**Monument Glamping II:**

**ADDRESS:**  
18045 HIGHWAY 83  
COLORADO SPRINGS, CO 80908

**SITE PLAN**

File Number:  
AL2318

Typical Site Dimensions

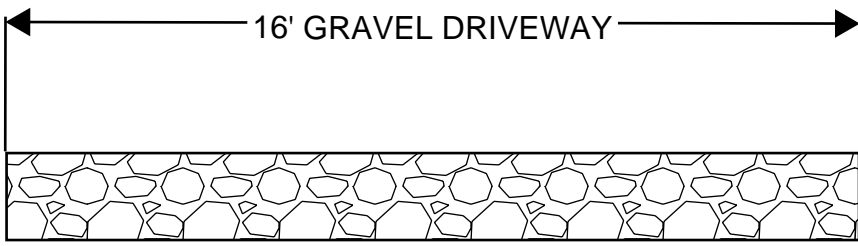
this does not match the elevation plans that the sites can be up to 400 sq ft, please depict another layout for larger sites in addition to this

**RESPONSE:** This is a "typical" site dimension. Per the definition of a recreation camp, each of the 24 proposed spaces may be occupied by either a tent, yurt, other temporary facility, or a permanent structure.

Typical Driveway Cross Section

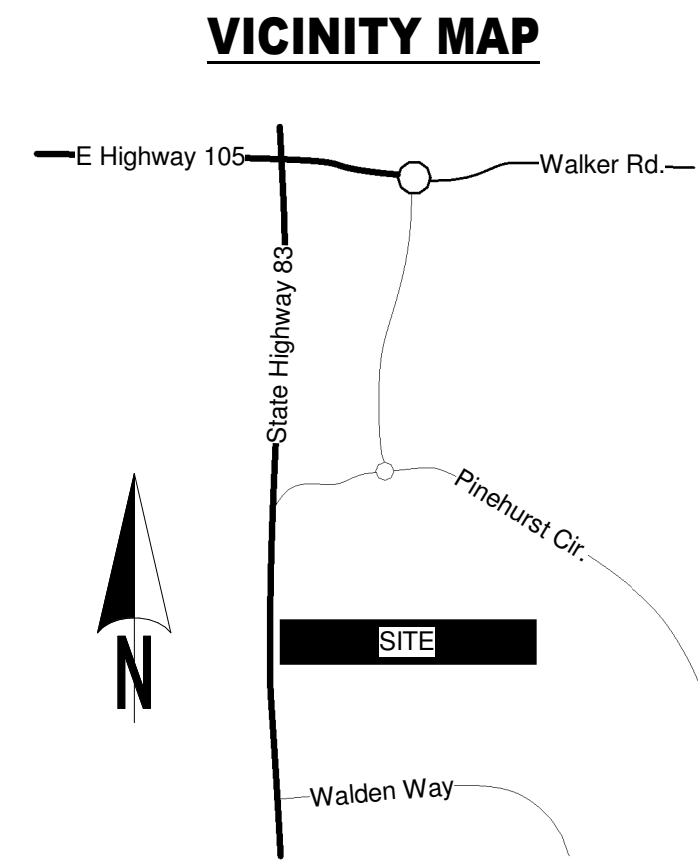
Update road cross section width to 20ft per FD comment.

**RESPONSE:** meeting and site walk has occurred with fire. Fire requires "passable surface" sporadically, as shown. the final design will be determined at the time of the site development plan in coordination with Fire.

Monument Glamping II
18045 HIGHWAY 83, COLORADO SPRINGS, CO 80908

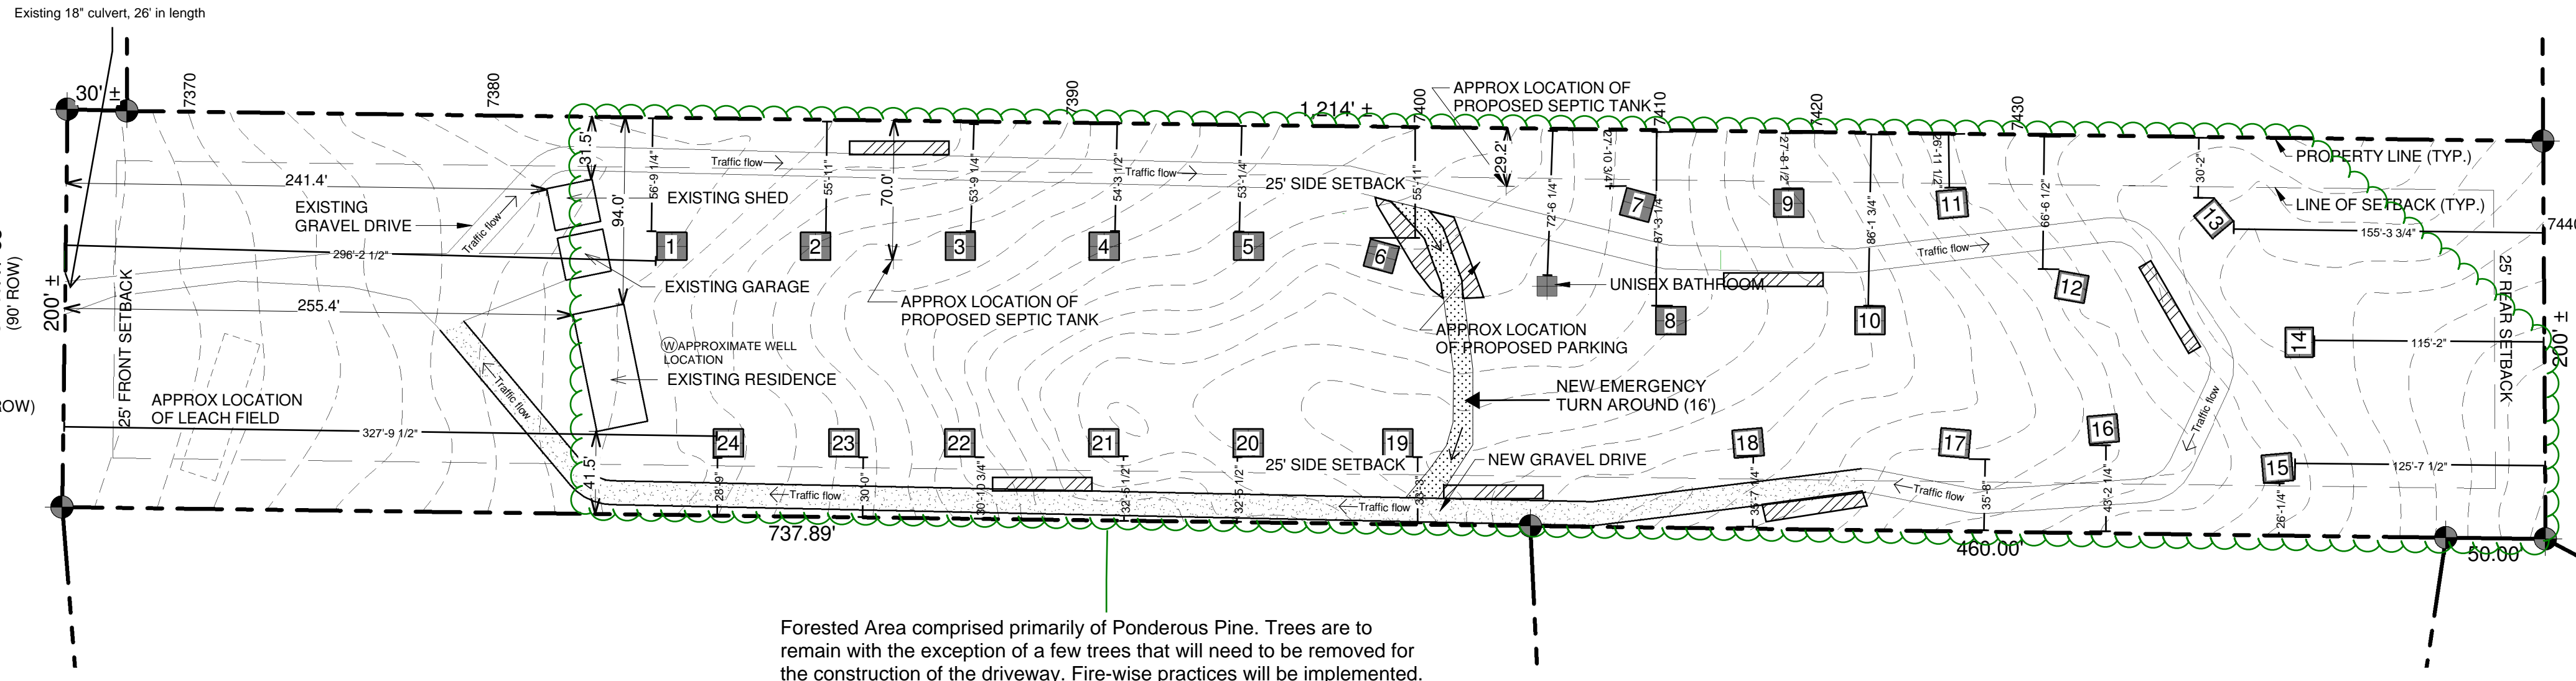
Signage? **RESPONSE:** If signage is proposed, this will be addressed with the site development plan. note added. Please depict location and dimensions

Please depict on site plan if they are still there or moved or being used for the rec camp business

Where will parking be and how many spots?

ADA spots?  
Per the code 1 spot/ structure

Where is the dumpster/ garbage receptacles?

Screening?

**RESPONSE:** We have specified the spaces and are not specifying the type of unit for each space. This is the nature of a recreation camp.

**RESPONSE:** A minimum of one parking space will be included within each one of the spaces. A note has been added to indicate a detailed parking plan will be provided with the site development plan.

**Response:** note added to indicate this will be determined at the site of the site development plan.
